Great Yarmouth Third River Crossing Application for Development Consent Order

Document 7.4c: Design Report: Appendix C – RSA Stage 1 Report

**GREAT YARMOUTH:
THIRD RIVER CROSSING**

STAGE 1 SAFETY AUDIT

Figure 1.1 – Location of Highway Geometric Departures

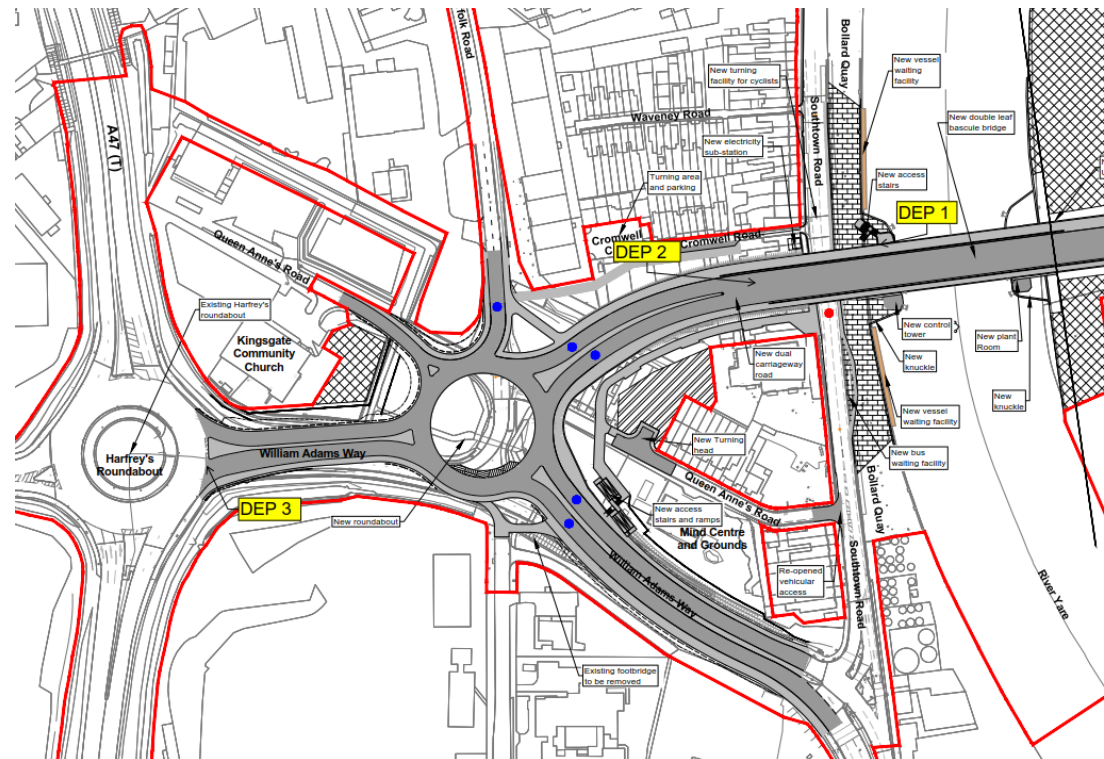
- Discontinuous parapet / barrier provision where *TD19/06 – Requirement for Road Restraint Systems* would mandate linking two adjacent systems with less than 50m between them. This results from the need to provide stepped pedestrian access to a viewing platform on the northwest corner of the bridge. Notwithstanding this requirement, the break in the parapet is coincident with a proposed Class N1 containment Vehicle Restraint System (VRS), separating the eastbound bridge carriageway from the proposed shared pedestrian / cycle facility. Hence, the proposed VRS would prevent an errant vehicle from reaching the gap in the bridge parapet wall.

- Substandard median separation between opposing carriageways of 0.8m where *TD27/05 - Cross-Sections and Headrooms* would mandate 1.8m. The new bridge will be subject to a 30mph speed limit and adjoins constrained, entirely urban highway environments. The geometry of the link has been designed in accordance with TD9/93 and the risk of cross over collisions is considered low.

- Substandard entry path radius where the scheme ties into the existing A47 / William Adams Way. Existing entry path radius is more than three times the 100m maximum mandated in *TD16/07 - Geometric Design of Roundabouts*. The proposed scheme improves this somewhat, but the value is still more than double the mandated value.

3.1 Problem – failure to give way / tail end / loss of control collisions

Location – east arm of existing A47 / William Adams Way roundabout

Whilst the scheme improves the existing entry path radius at this arm, the resultant value is approximately 250m, compared with the absolute maximum of 100m from *TD16/07*.

Entry path radius is the most important determinant of safety at a roundabout and an excessive figure allows vehicles to enter the roundabout and circulate at higher than desirable speeds. This increases the risk of failure to give way, tail end, or circulatory carriageway loss of control type collisions due to the higher approach speeds engendered by the geometry. Consideration of the six year (to end January 2019) accident records for this junction shows six collisions of this type occurring on this east arm. The provision of the third river crossing will increase traffic flow at this roundabout and it may therefore be anticipated that an increased number of collisions will occur.

Recommendation – a subsidiary deflection island should be provided between the nearside and central lanes. See *TD51/17 – Segregated Left Turn Lanes and Subsidiary Deflection Islands at Roundabouts*.

Preliminary investigations into the provision of a TD 51/17 compliant subsidiary deflection island and associated hatched markings, between the nearside and straight-ahead lanes, have been carried out and these are summarised on the attached sketch. The sketch is based on the provision of a physical subsidiary deflection island, as opposed to a non-physical subsidiary deflection island, as the latter are subject to abuse by drivers crossing the hatched road markings and therefore are less effective than physical islands. The key findings from this exercise, detailing why the recommendation is not accepted, are as follows:

- In addition to providing appropriate lane widths, the subsidiary deflection island cannot be accommodated within the proposed carriageway width without widening the carriageway on the nearside over the length of the

hatching shown. Lane widths (bold lines on sketch) of 3m have been used to develop the indicative layout shown on the sketch and this would require nearside carriageway widening of up to approximately 1.3m, however, the extent of widening required would increase to approximately 3.25m if 3.65m wide lanes were required on this section of William Adams Way. The nature of the site constraints at this location, which include the adjacent Southtown Common, are such that it is not feasible to consider carriageway widening of this magnitude.

- There is concern that the proposed start of the hatching for the subsidiary deflection island is located too close to the exit from the new roundabout on William Adams Way which would preclude the provision/siting of lane directional signs in advance of the start of the hatching. As a result, there is concern that introducing hatching at this location means drivers would have to make a decision on which lane to take resulting in driver hesitation with some drivers braking suddenly and could result in lane change and rear shunt collisions in the vicinity of the westbound exit from the roundabout.

To mitigate the safety concerns raised, in particular those regarding high entry speeds due to non-compliant entry path radius, it is proposed to provide appropriate visibility screening in the central reserve on the approach to Harfrey's roundabout to as described in TD 16/07 paragraph 8.8. Further details of the type of screening proposed would form part of the Stage 2 RSA submission.

Network Management Decision: Accepted on the basis that land required for additional widening on the south side of William Adams Way is not available. The suggestion of installation of vegetation screening to reduce likely roundabout entry speed is accepted and will be considered in detail at Stage 2 Audit.
